**RE: RESPONSE TO REQUEST FOR FURTHER INFORMATION
 SHOALHAVEN STARCHES EXPANSION PROJECT MP06_0228-Mod-21**

I refer to the Department's letter dated 30th September 2021 seeking further information in relation to the above Modification Application. This submission has been prepared in response to this request.

FERMENTERS #18 & #19.MOD 21.

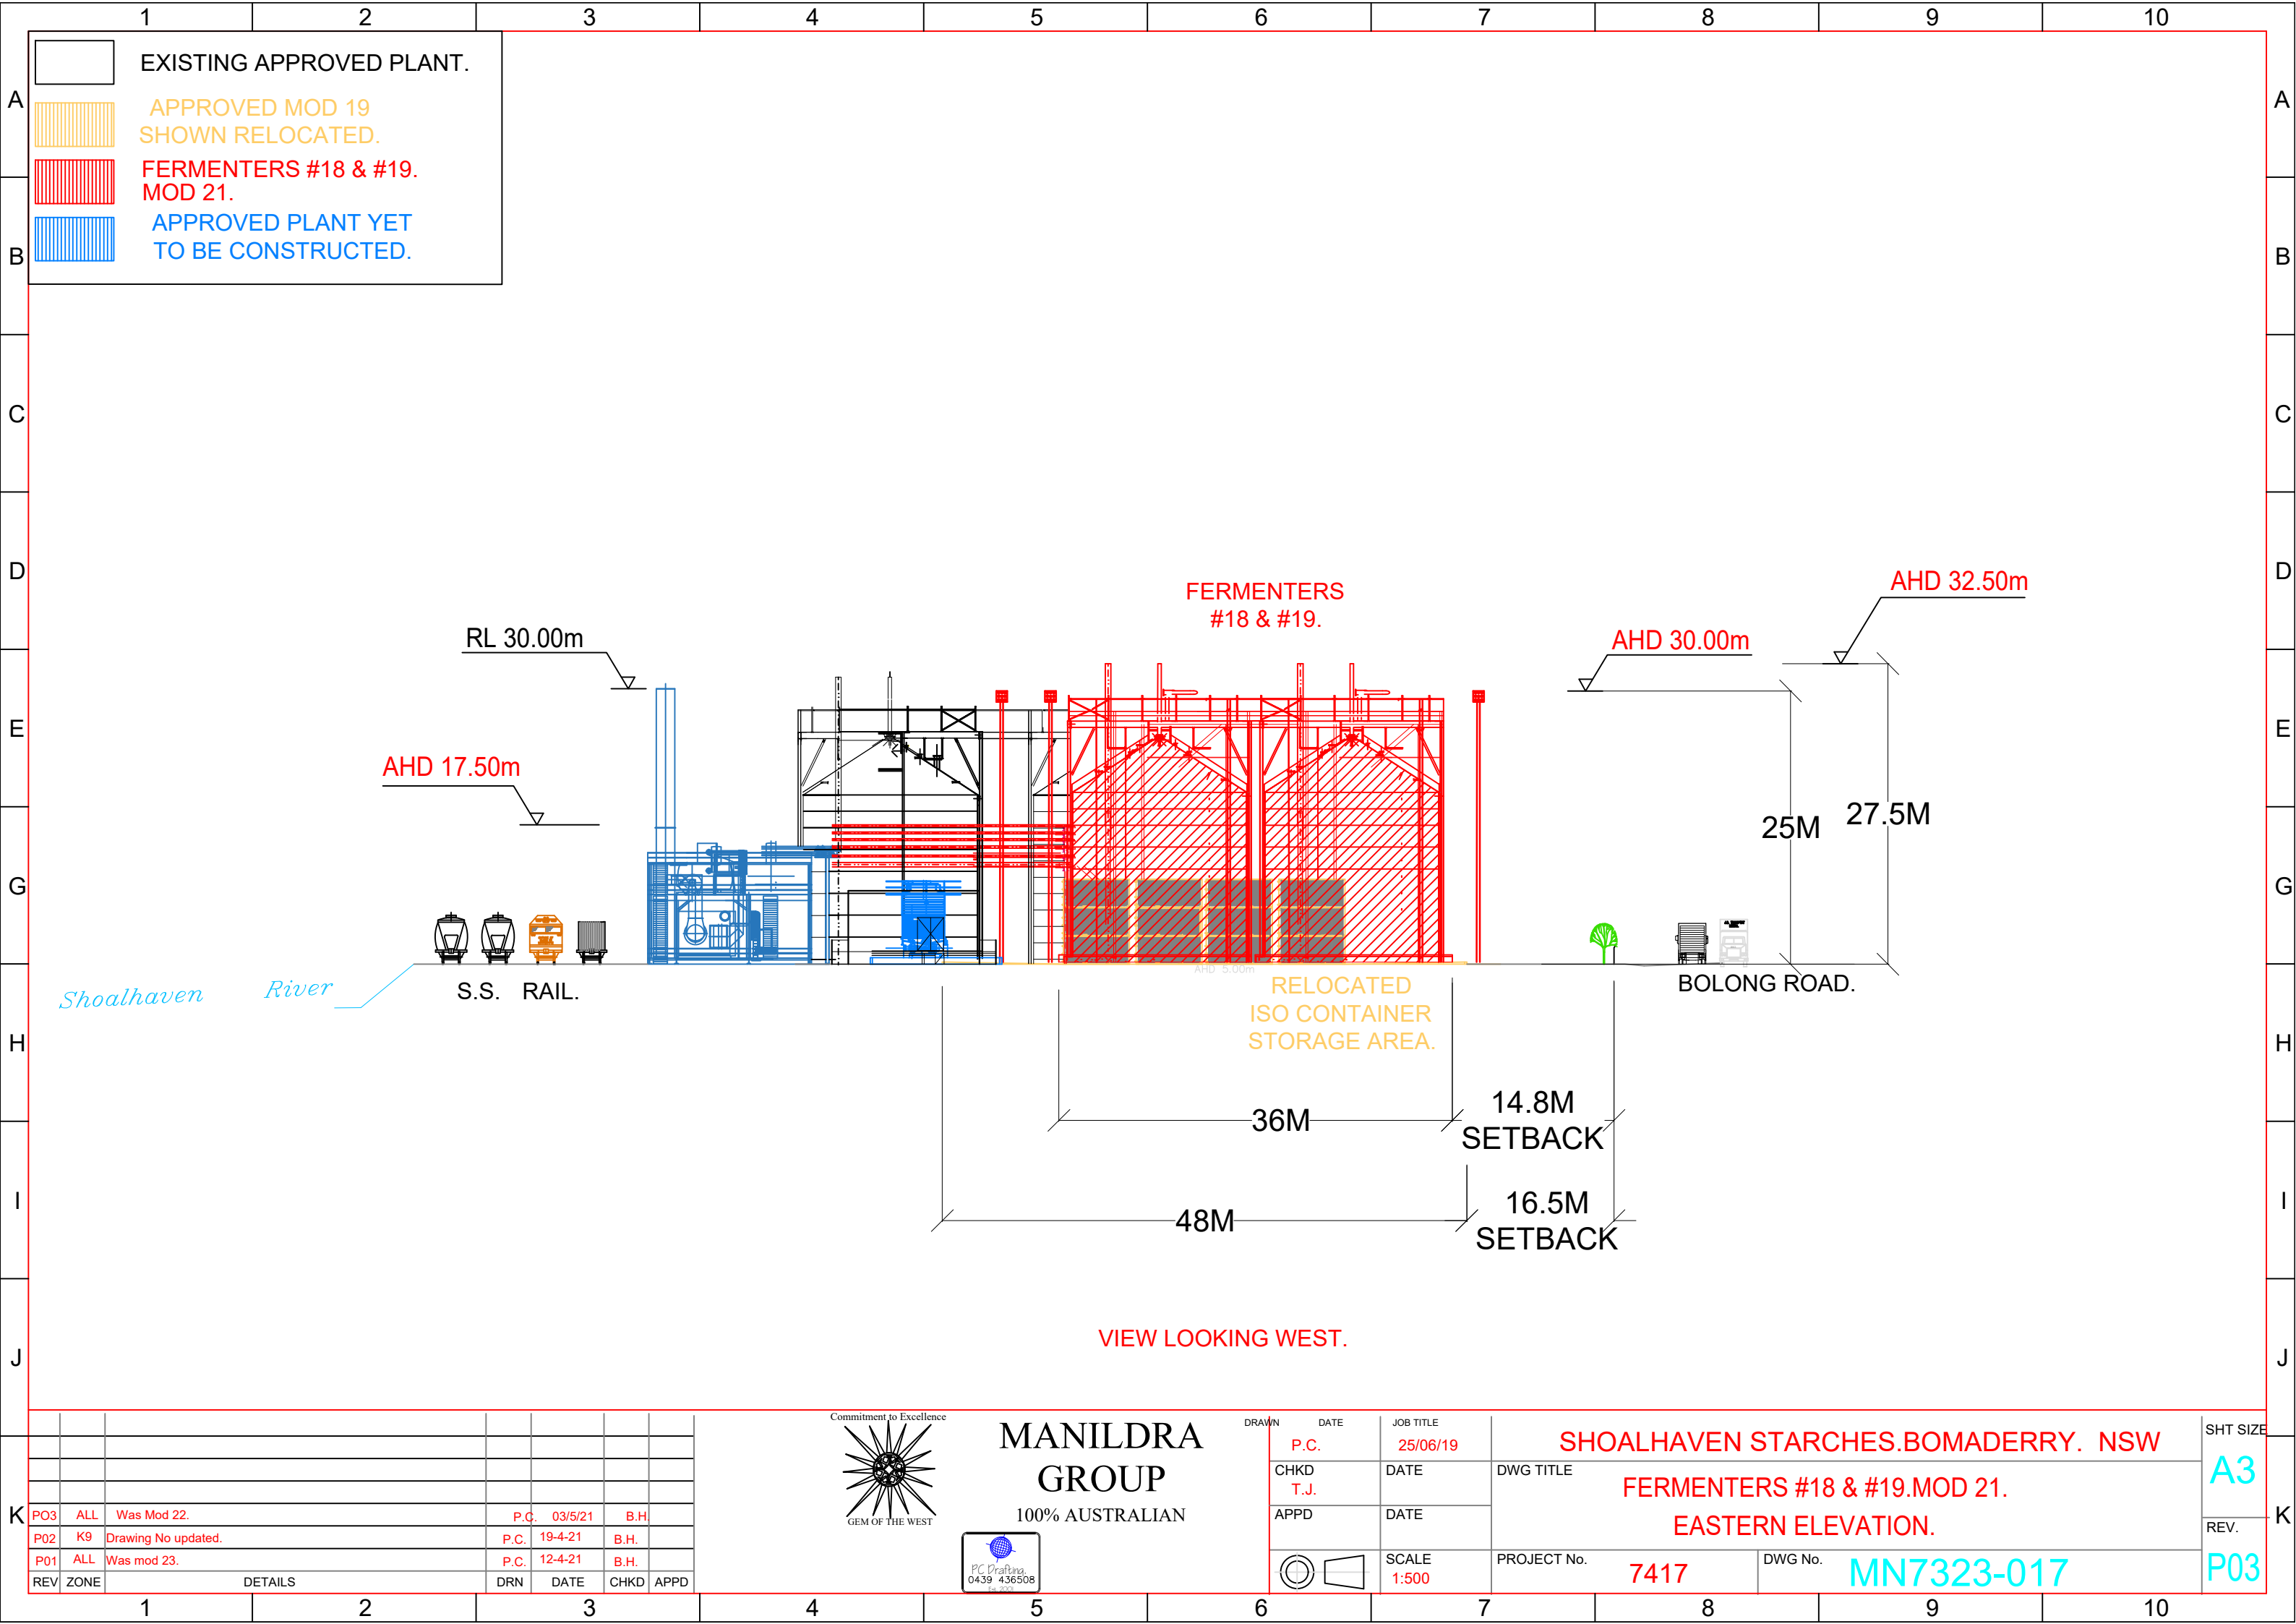
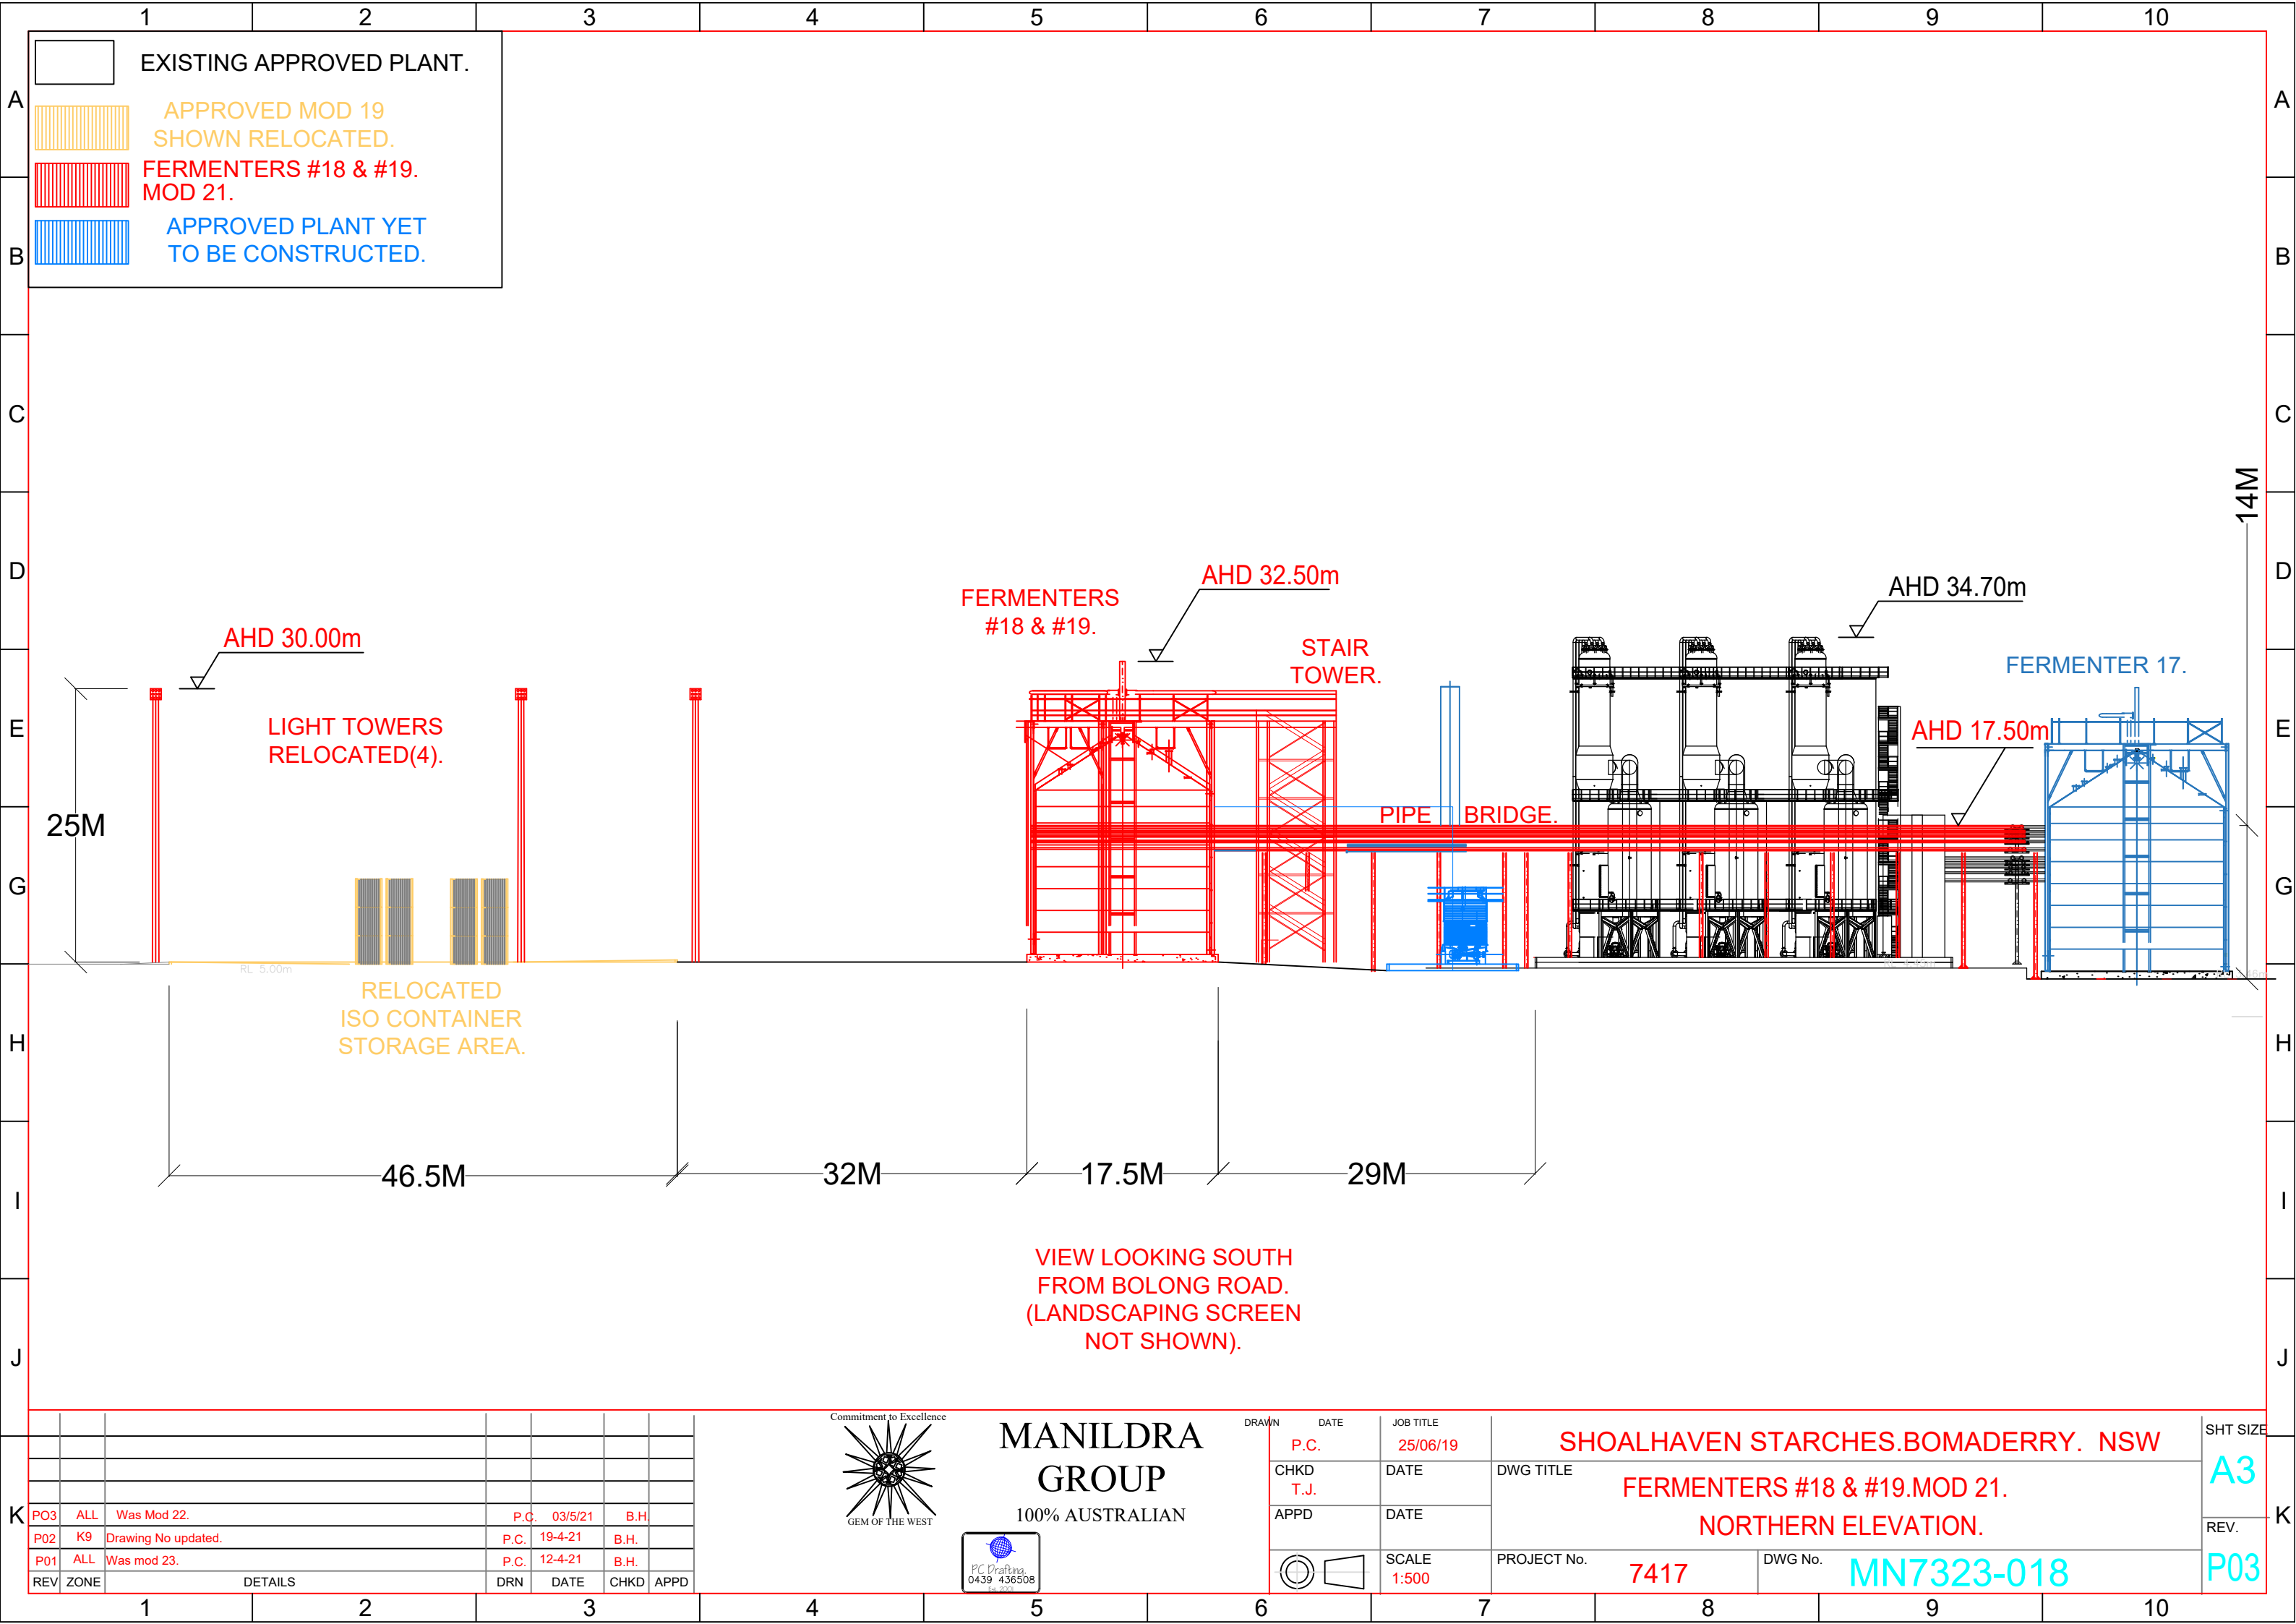
3. *Section 5.3 of the SEE identifies current foaming and capacity issues with existing fermenters requiring an additional two fermenters to be proposed to accommodate fermentation capacity. The Department requires further information to elaborate on the foaming overflow issues encountered by the existing fermenters and if the proposed additional fermenters are anticipated to encounter the same overflowing issues.*

4. *Furthermore, the Department seeks clarification on if the issues are temporary in nature and if the proposed additional fermenters would be made redundant long-term if foaming issues are rectified in the fermentation process. If the foaming issues are temporary in nature, the Department requests further information on any consideration of alternative measures undertaken to either resolve or mitigate the issue.*

Shoalhaven Starches advise that one of the components in wheat that will increase foaming is soluble protein. It is likely that the current foaming issue is the higher soluble protein levels in the fermentation liquour causing increased foaming. Soluble protein levels in the wheat will vary from season to season based on climatic factors and farming practices. The foaming and potential overflow issues arising within the fermenters can be compensated by reducing the fermenter levels within the individual fermenters which reduces their fermentation capacity and ethanol production.

Based on the response outlined in item 3 above, Shoalhaven Starches advise it is likely the foaming issues will be a long-term phenomenon and therefore additional fermenter capacity is required. The foaming issues have been mitigated by significantly increasing the anti-foam dosing in the fermenters and by reducing the fill level of the fermenters which reduces their fermentation capacity and ethanol production
